From: Simon Davis
Sent: 01 June 2020 16:06
To: Planning Scanning
Subject: FW: BR/55/20/PL

I have been looking at the site history and I believe that this new application is an amalgamation of BR/134/17/PL, BR/314/18/PL & BR/316/18/PL but without the 2 bed FF extension on BR/314/17/PL and with 1 extra bedroom in the new second floor. Thus it will represent a net loss of 1 bed over what has previously been approved. Is this your understanding also? Are there any other changes that I should be aware of? There will also be a loss of a bedroom on the ground floor to provide a new meeting / training room area. This is currently shown as a bedroom between

block plan

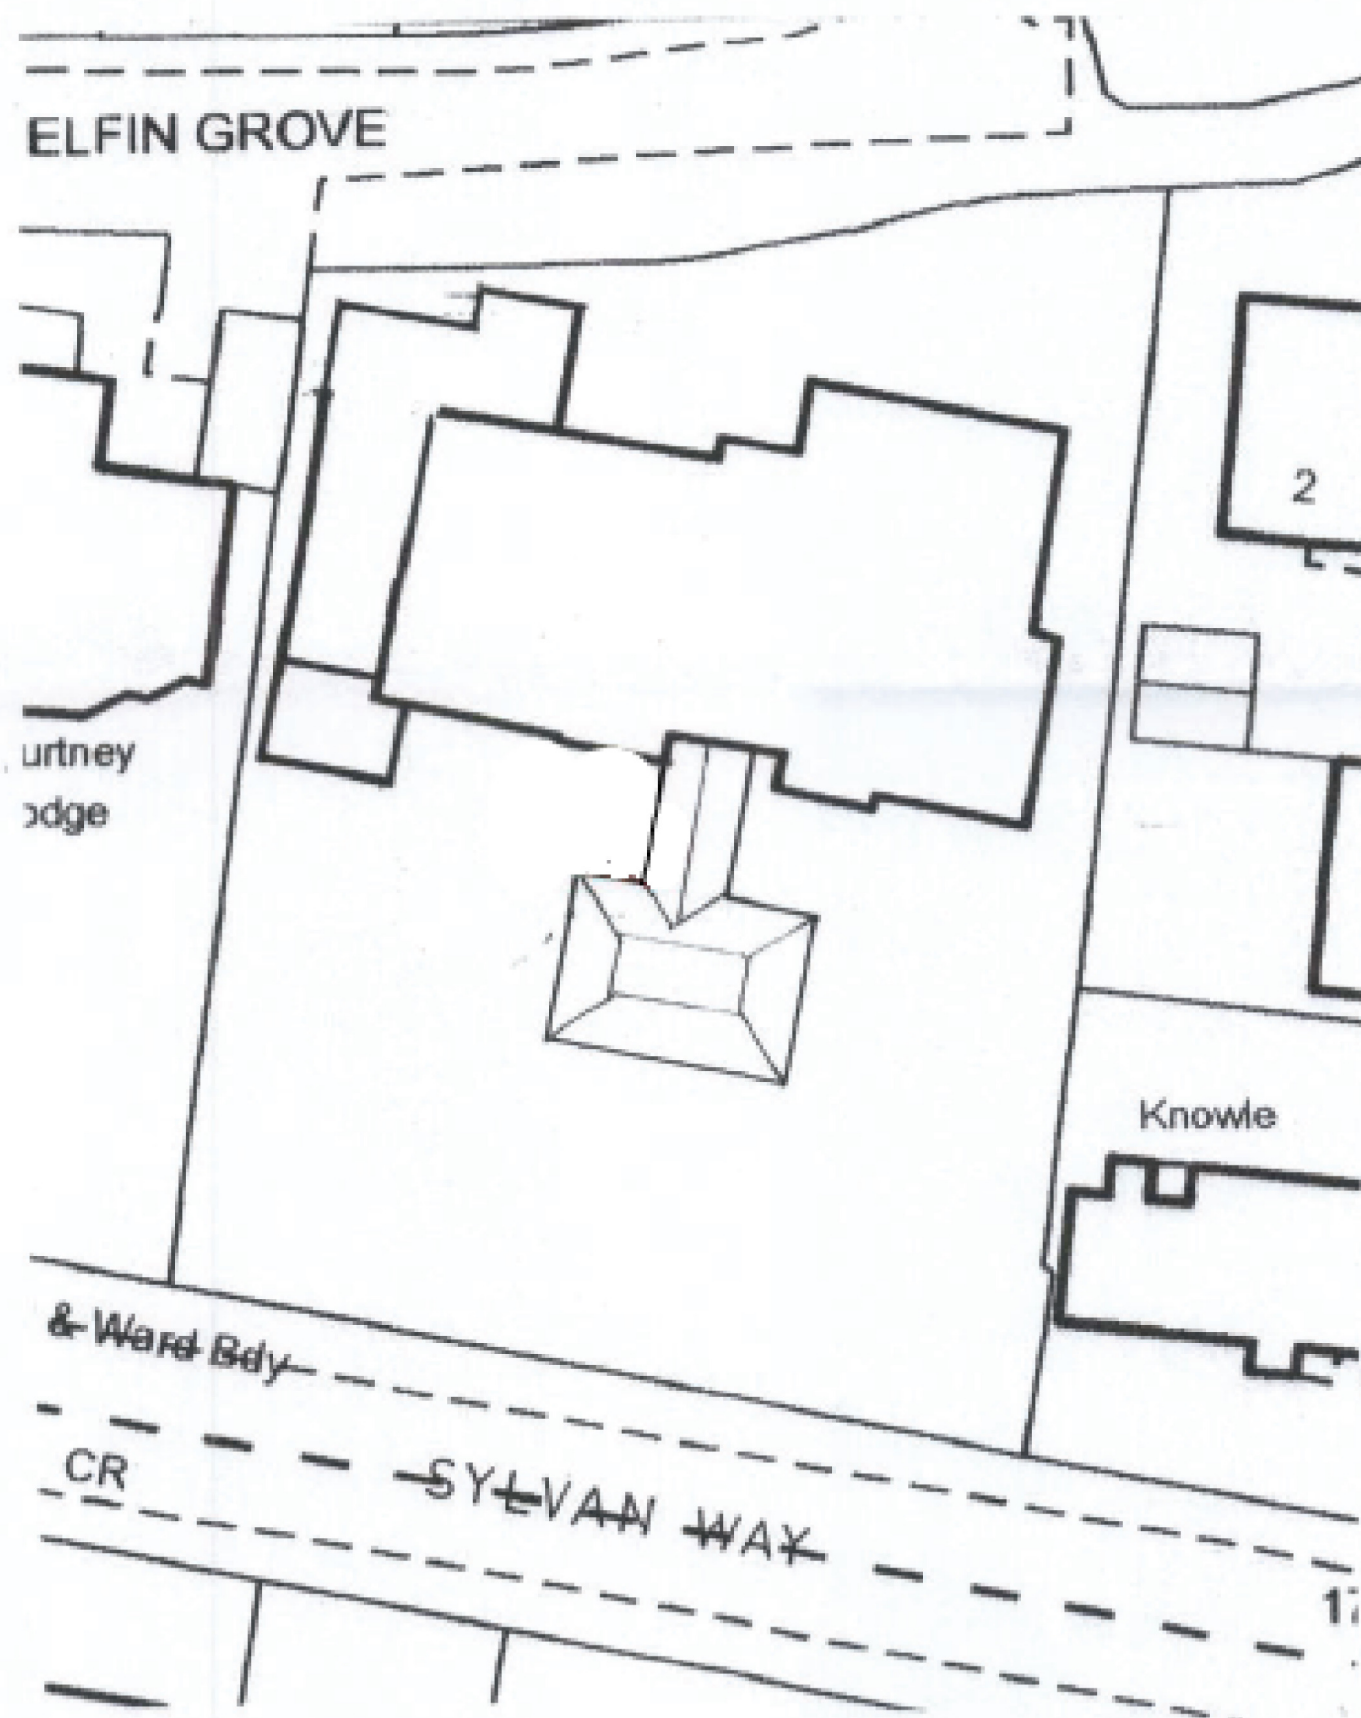
I note that on BR/134/17/PL there were changes shown to the access (widening) and the parking area with a minibus space shown where you now show two the new parking spaces. Also changes to the fence line & bin store. Can you advise why these changes are no longer required. I note that these changes were welcomed by Highways at the time. Our plans are to upgrade the minibub in the near future and begin parking this at one of our other sites in the area in order to better use the existing hardstanding car parking space. We had hoped this would avoid the need to loose further garden space at this site and protect the loss of trees. We are however happy to reconfigure the layout as per the revised parking layout to provide a solution more akin to what was previously welcomed, but not requested, by highways. Jack can you please send me a copy of this revised plan?

Proposed Ground Floor Plan

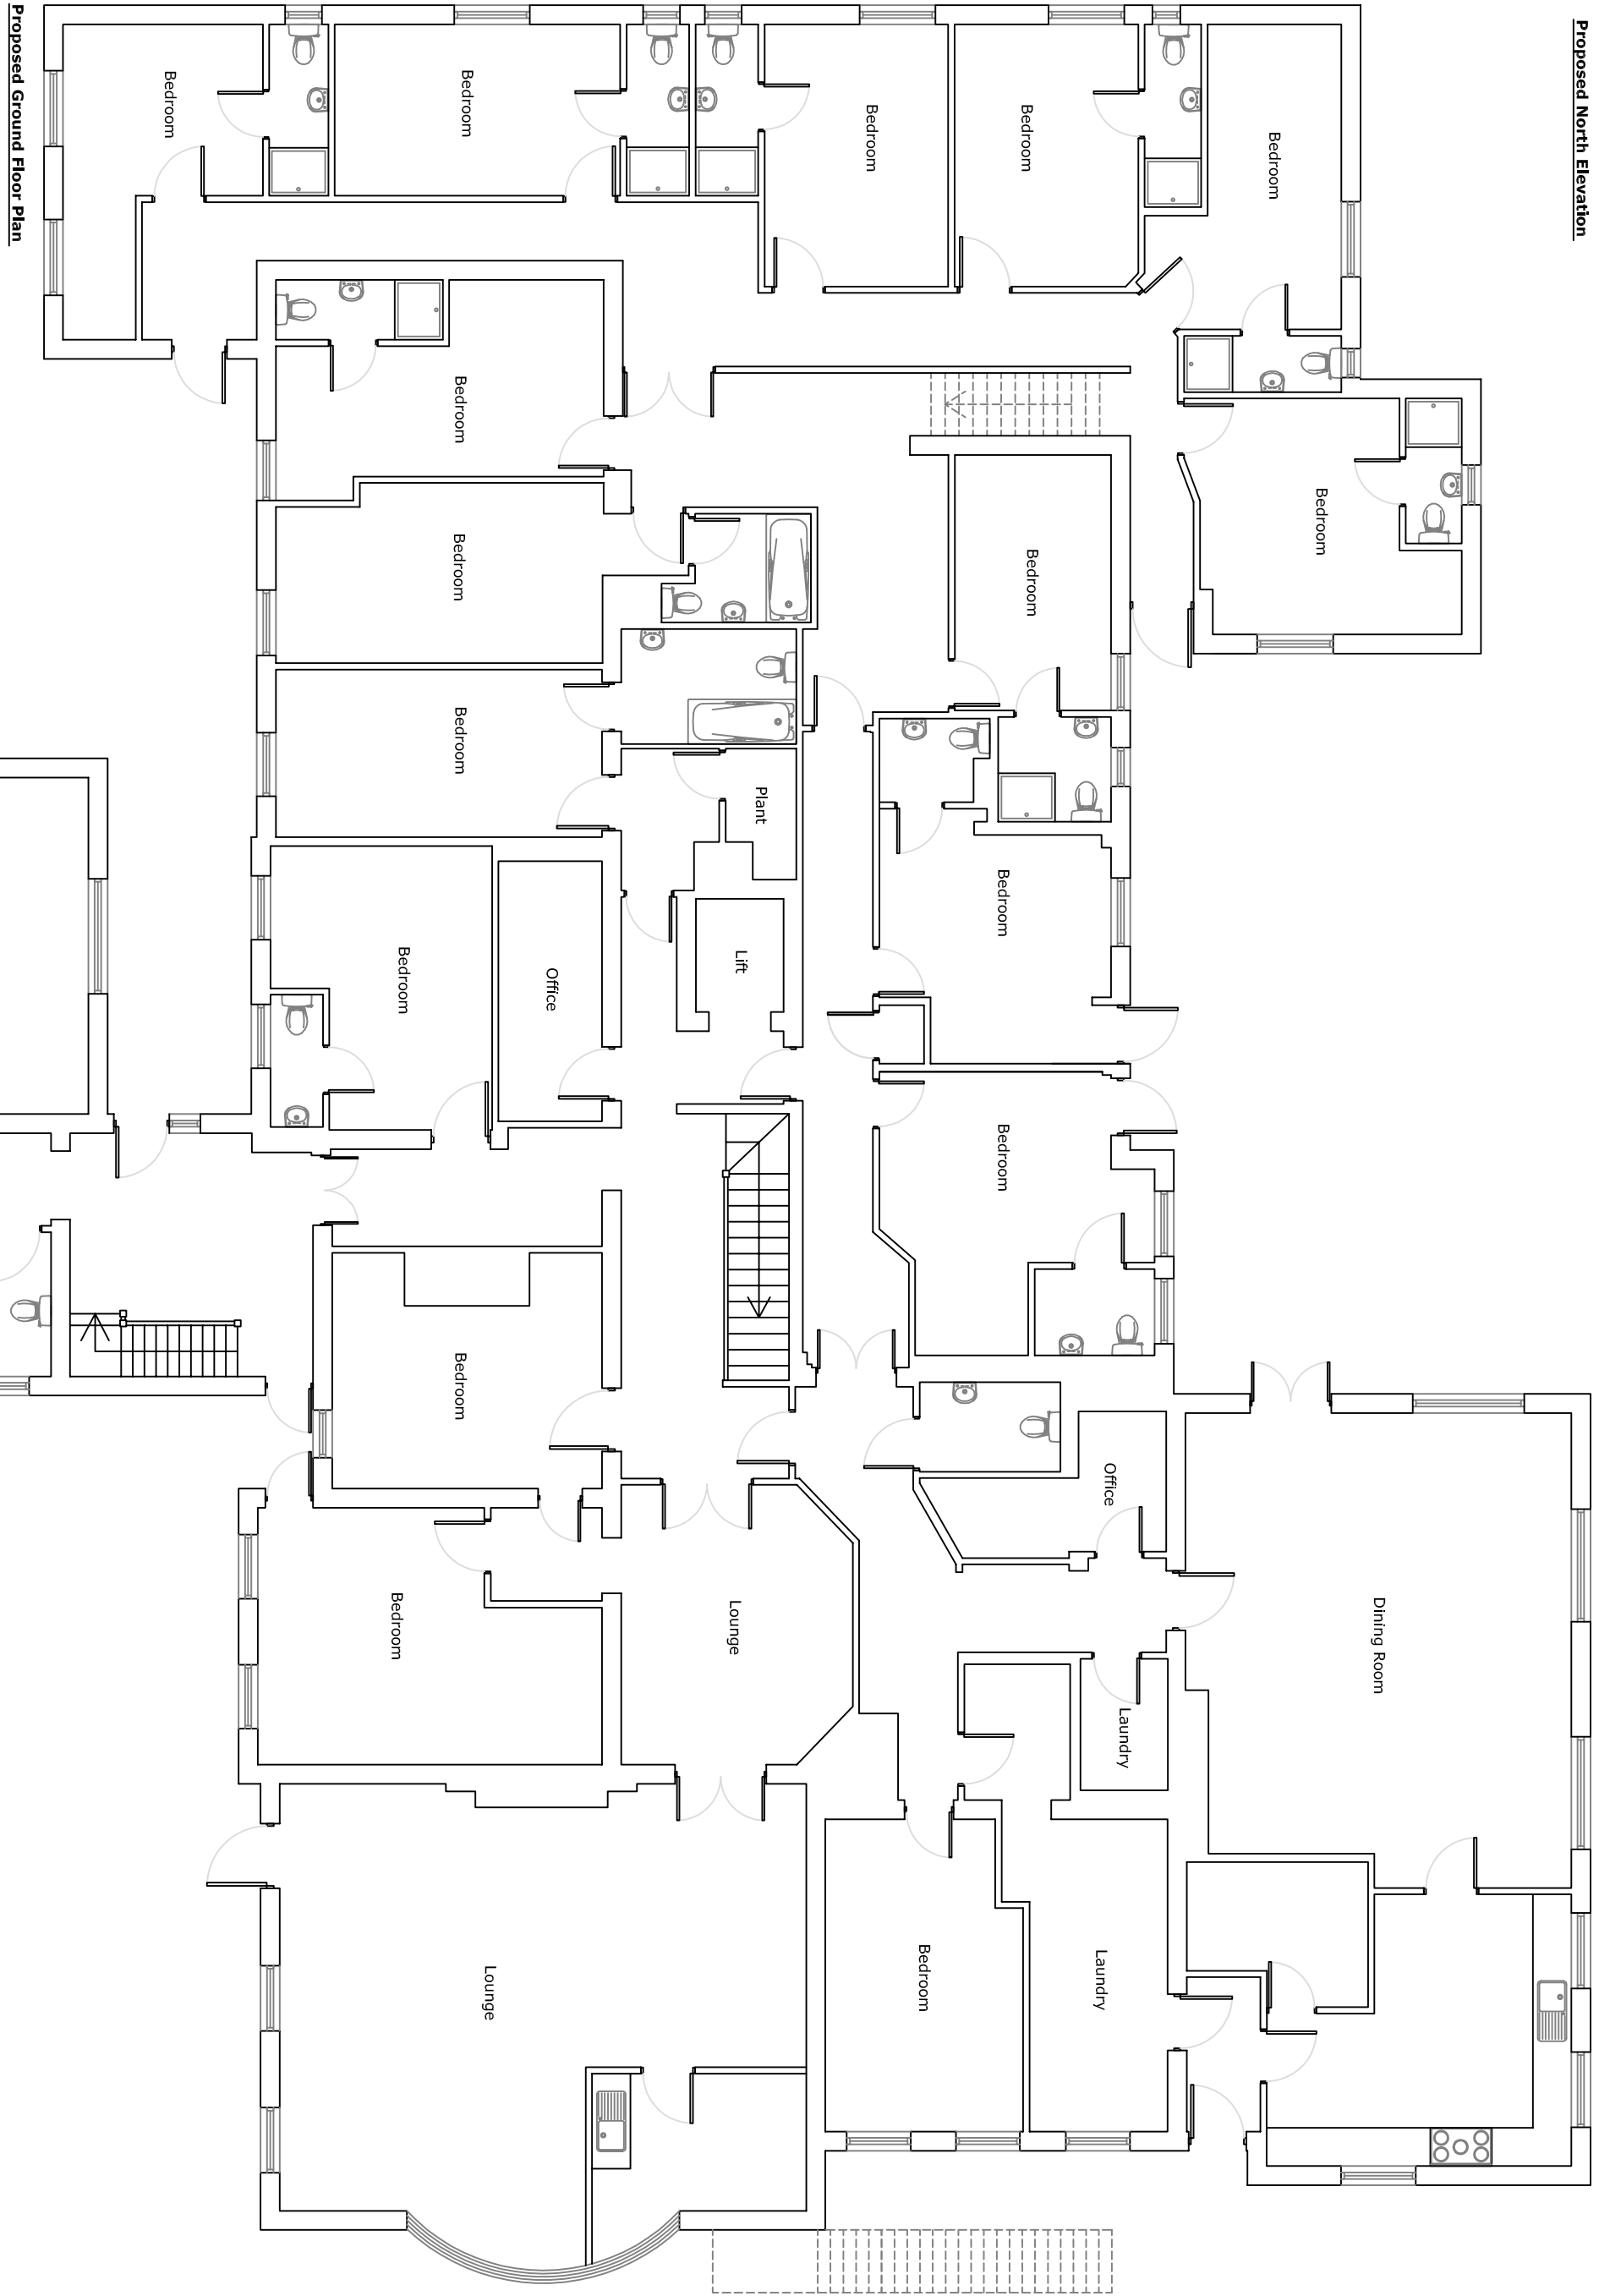
the lounge and laundry room. Jack can change plan and send this over. I wasn't aware we added a bedroom to the top floor? Can you check this?
